**RE: 1600 First Street Northwest, Loading Dock Remodel
Revised Grading and Drainage Plan
Engineer's Stamp Date 2-5-16 (File: J14D178)**

Based upon the information provided in your submittal received 2-5-16, the above-referenced revised plan is approved for Building Permit (SO-19 is no longer needed in this revised plan).

GRADING AND DRAINAGE PLAN

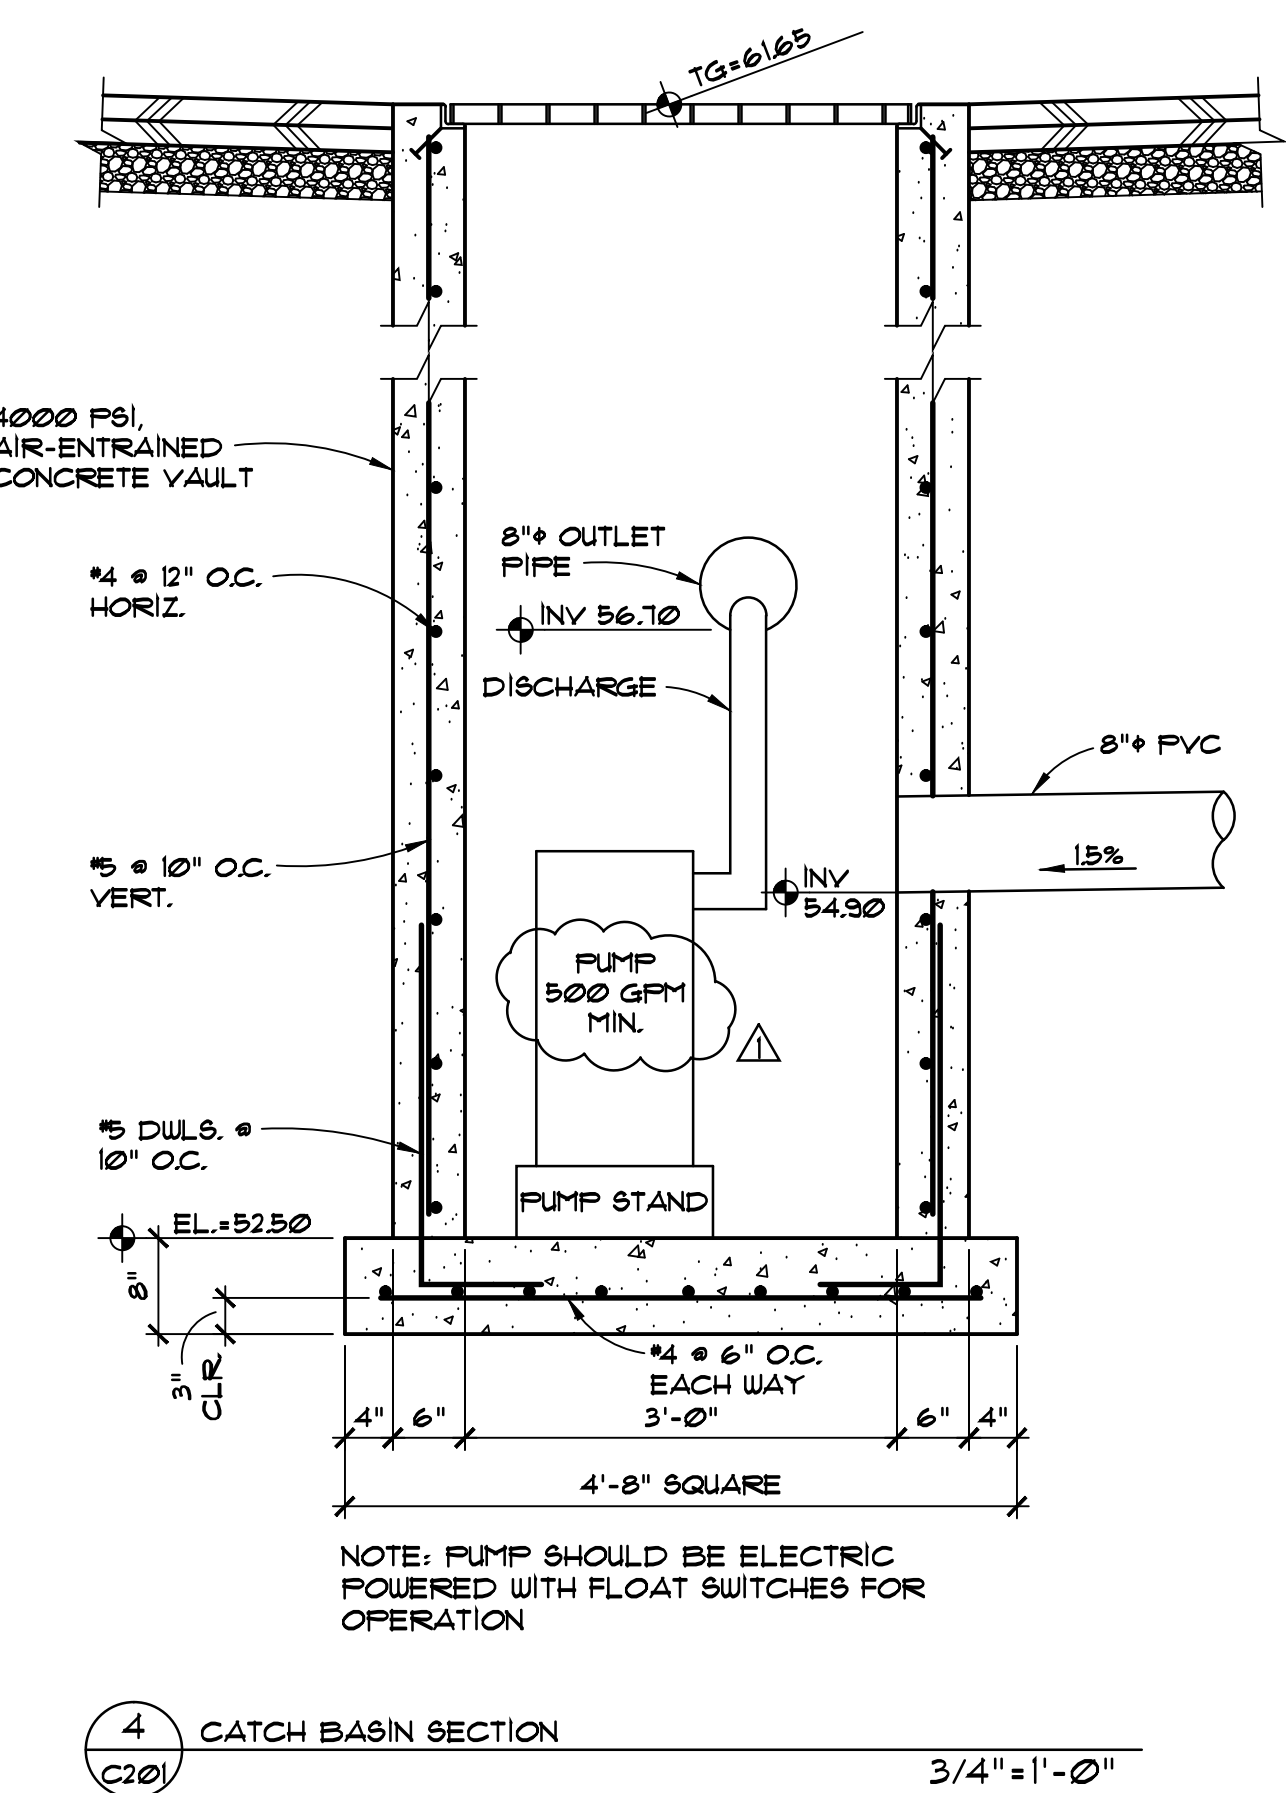
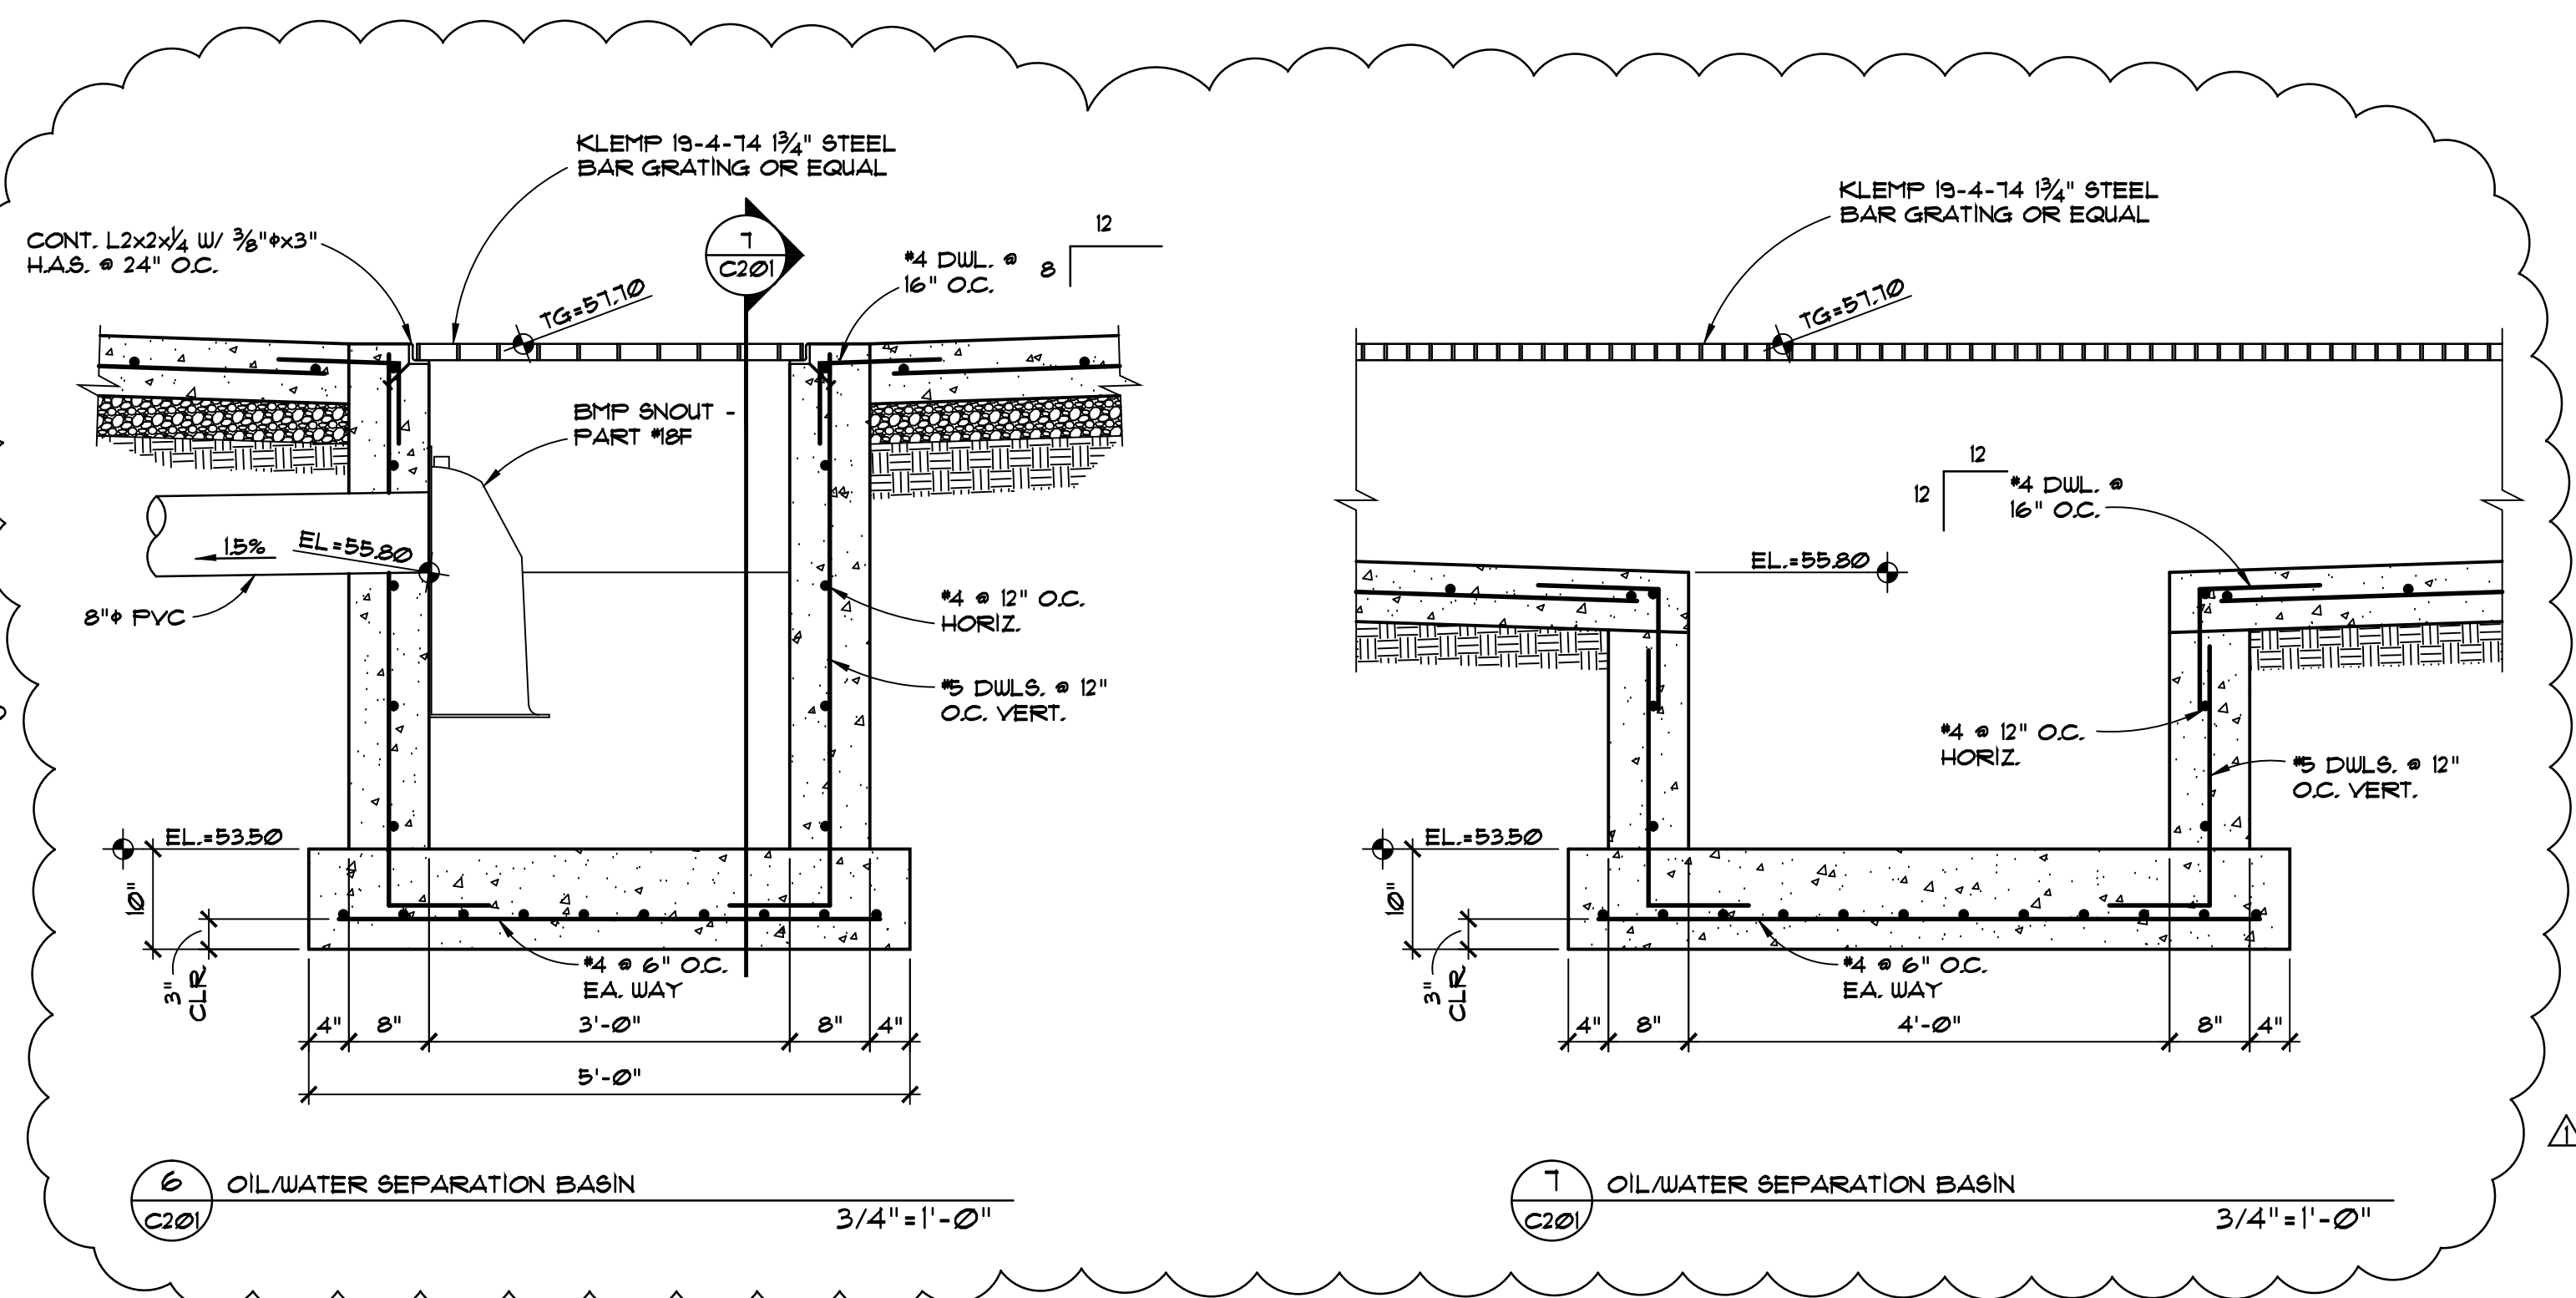
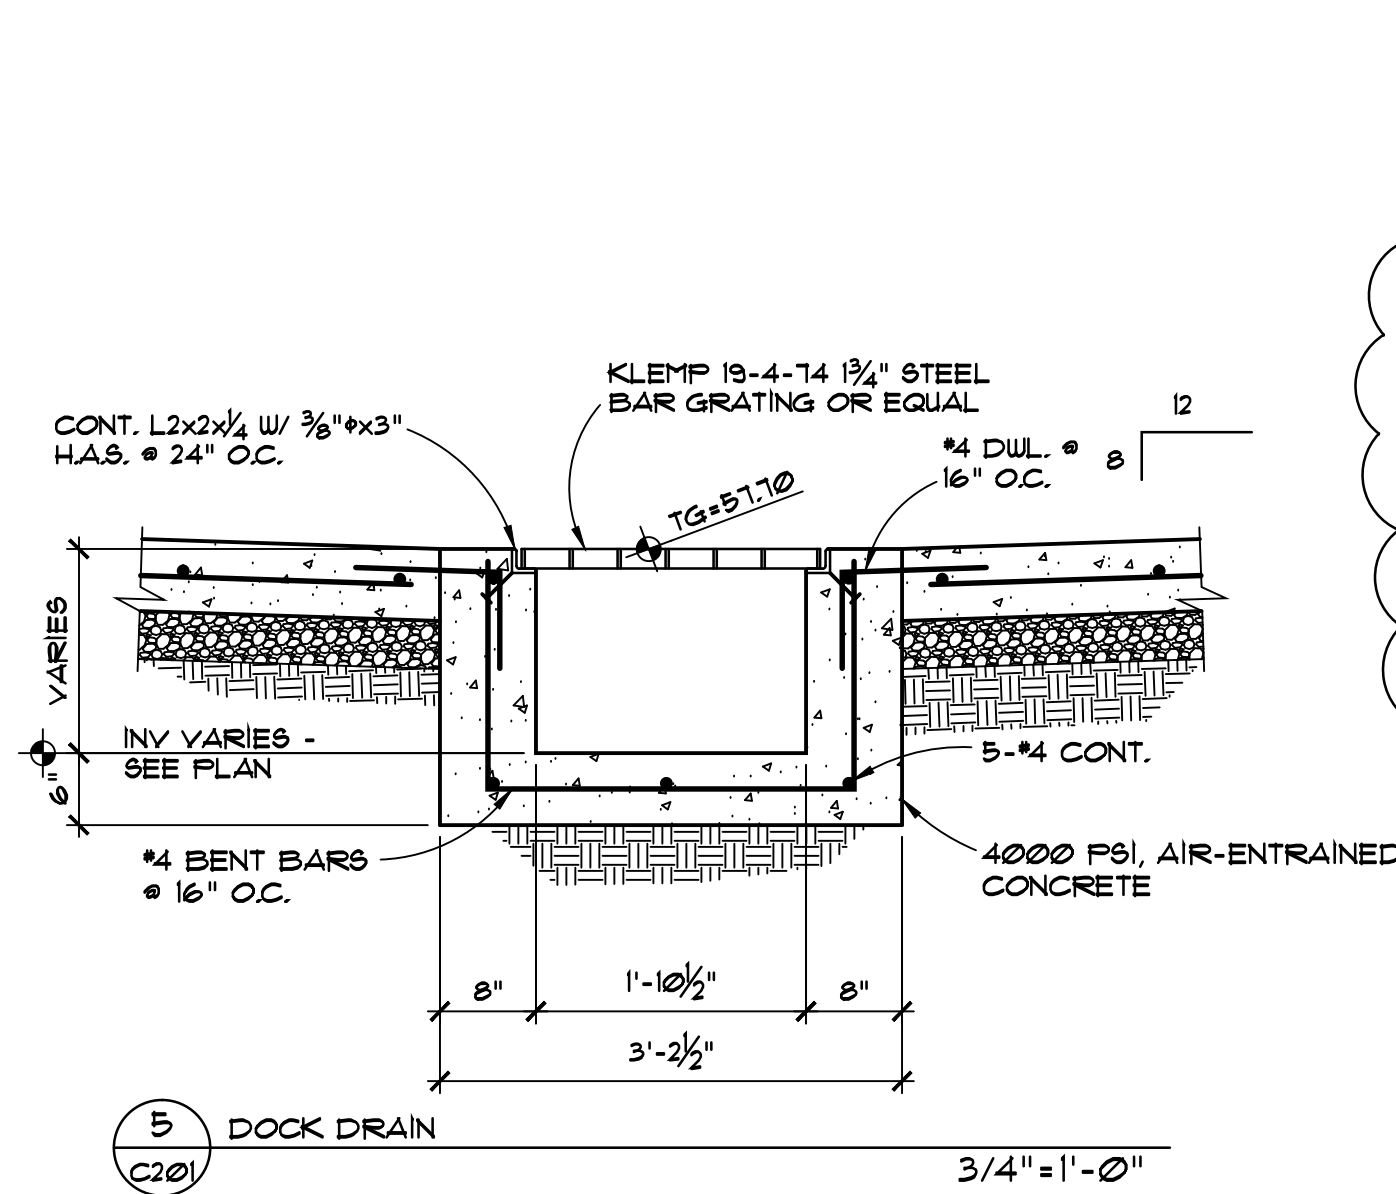
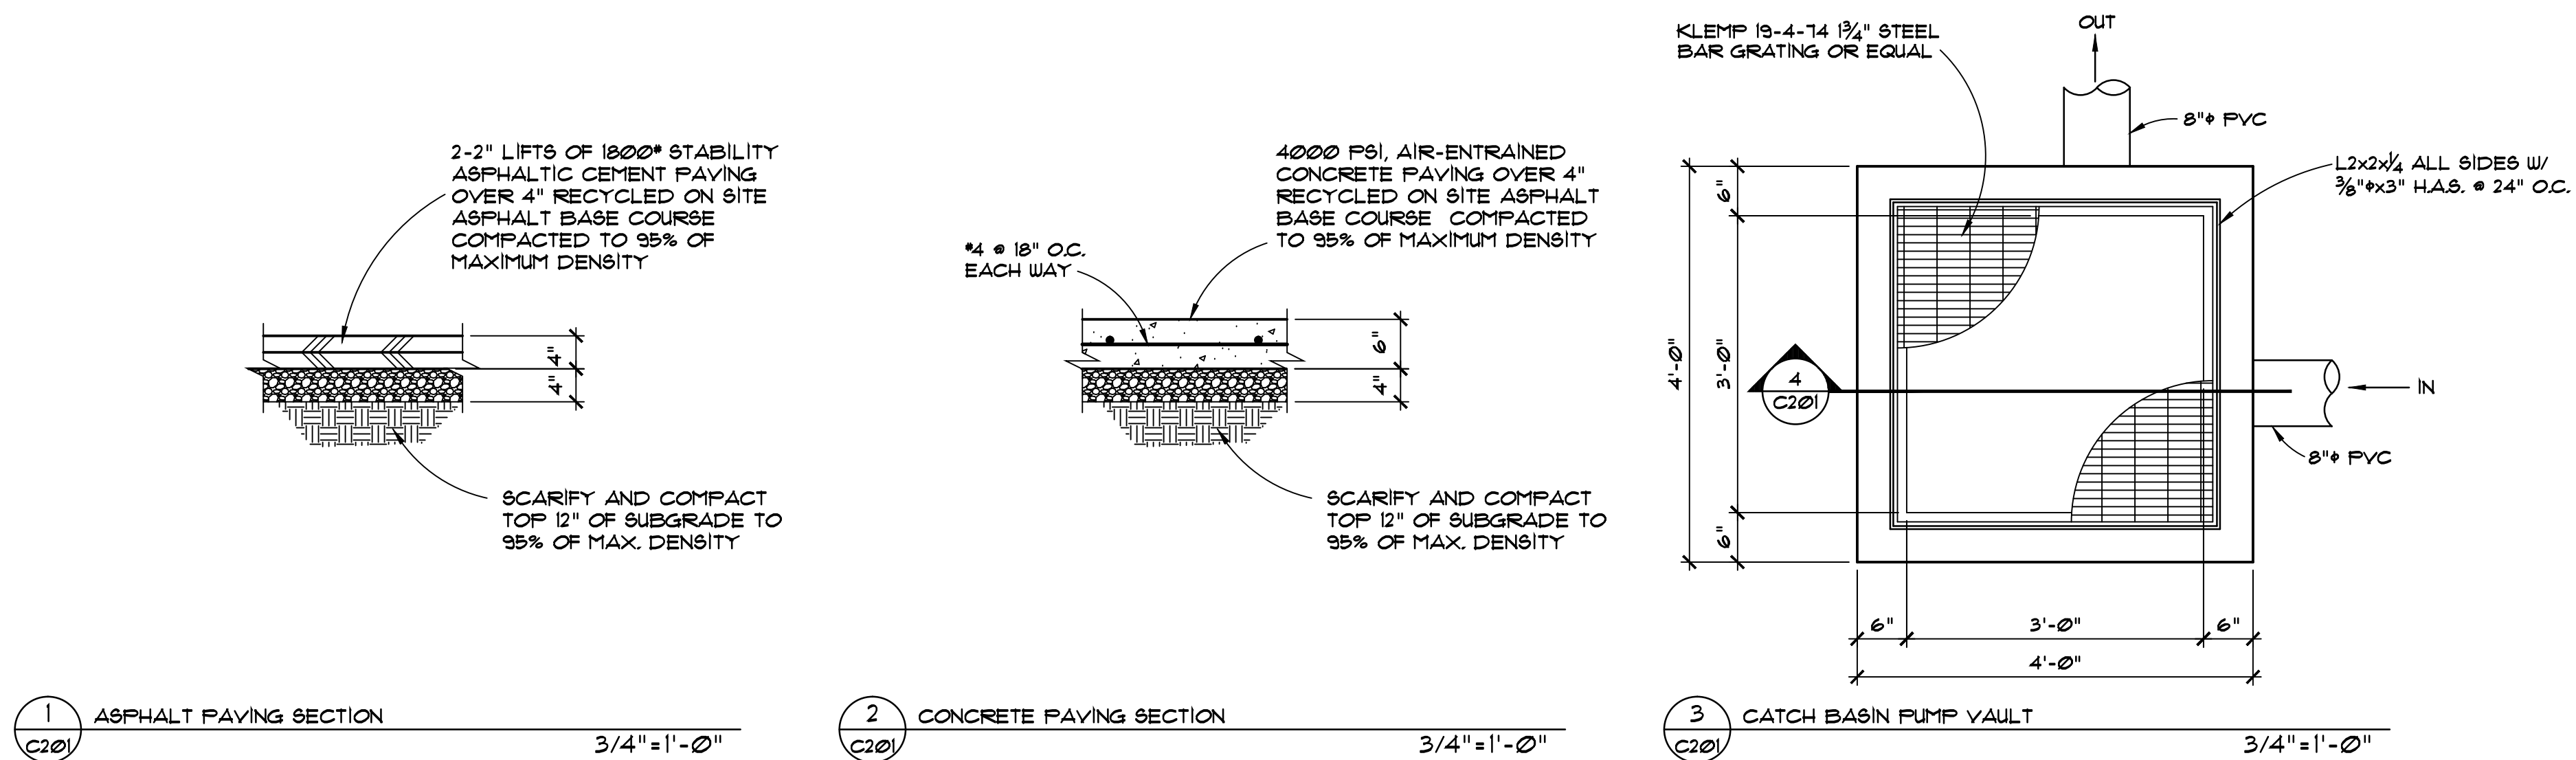
Please attach a copy of this approved plan in the construction sets when submitting for the building permit. Prior to Certificate of Occupancy release, Engineer Certification per the DPM checklist will be required. Please ensure that the existing piping under the sidewalk is completely cleaned.
